SUBJECT: **BRES2206-0006**
BUILDING RESIDENTIAL

Here are the results of all Inspections located at **465 FIELDSTONE DR:**

Inspection Type: ROUGH IN
Scheduled Date/Time: 11/22/2022
Completed Date/Time: 11/22/2022
Inspector: Justin Ryan McLeod
Result: DISAPPROVED
Remarks:

4 First Floor Plan Structural  
1/4" = 1'-0"

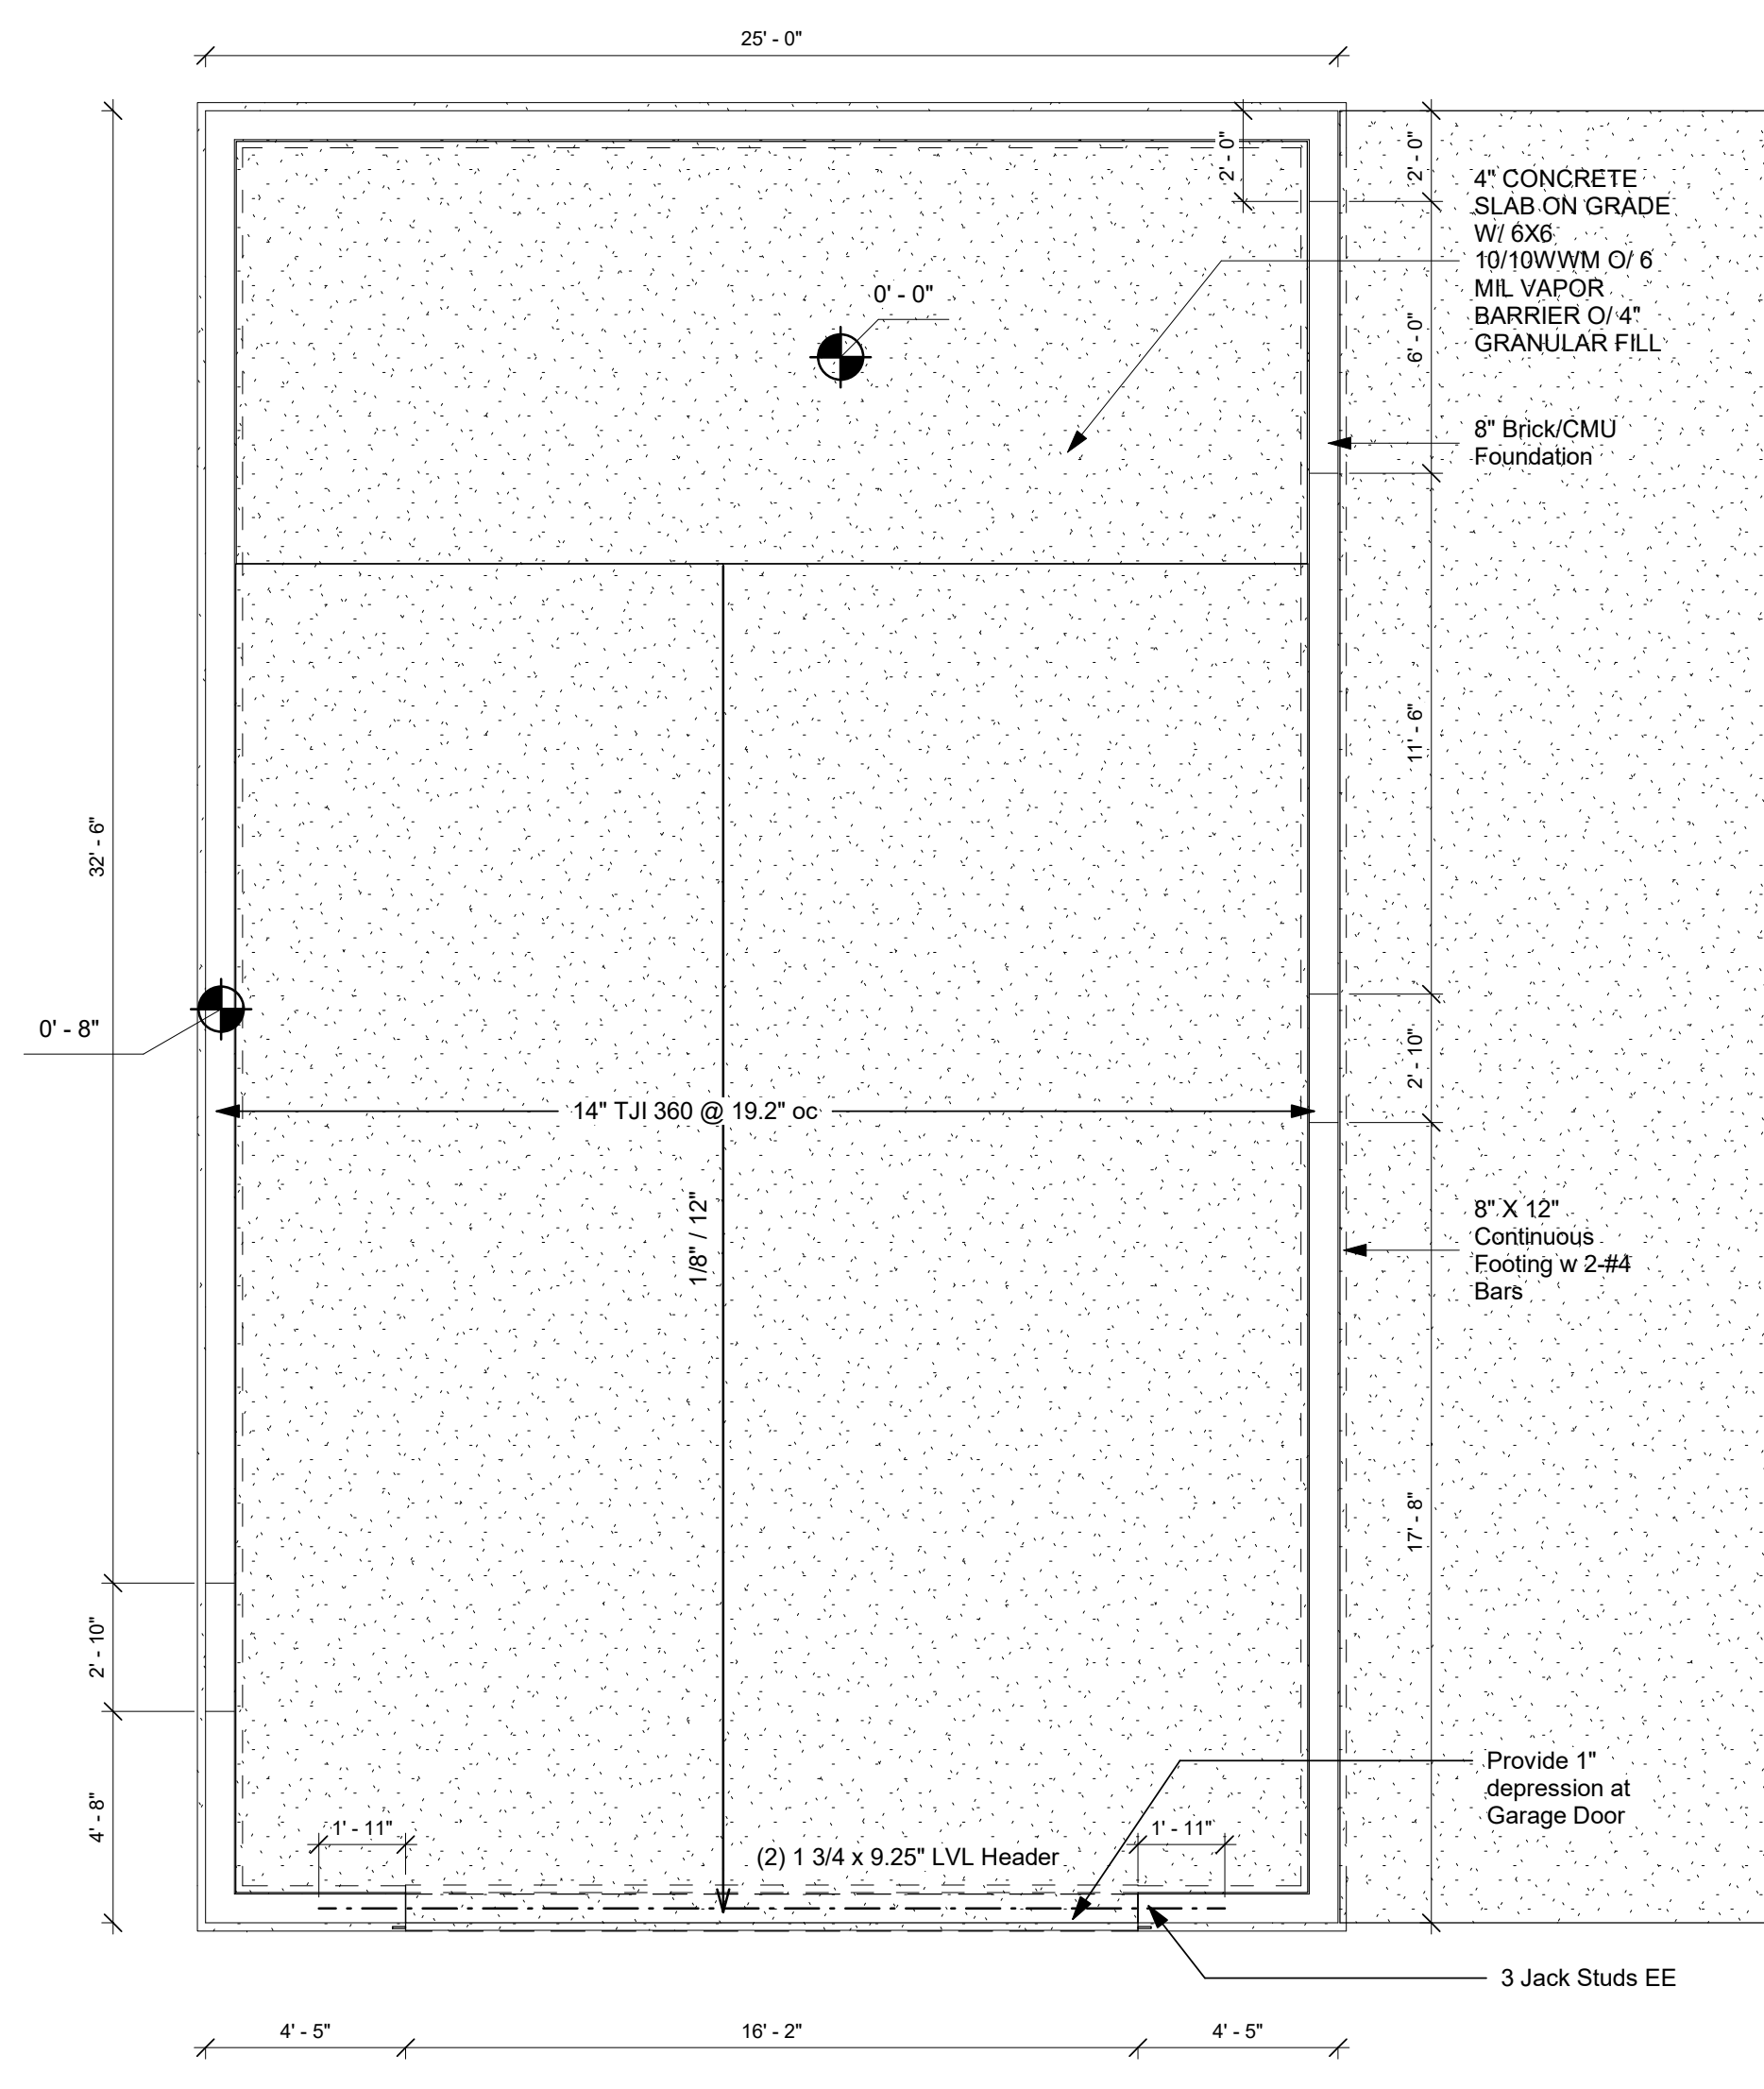
Notes: 1. Floor truss above stair landing that has two trusses hangered to it needs a hanger on each side. 2. The last rafter at rear left missing hurricane clip. Ok to insulate
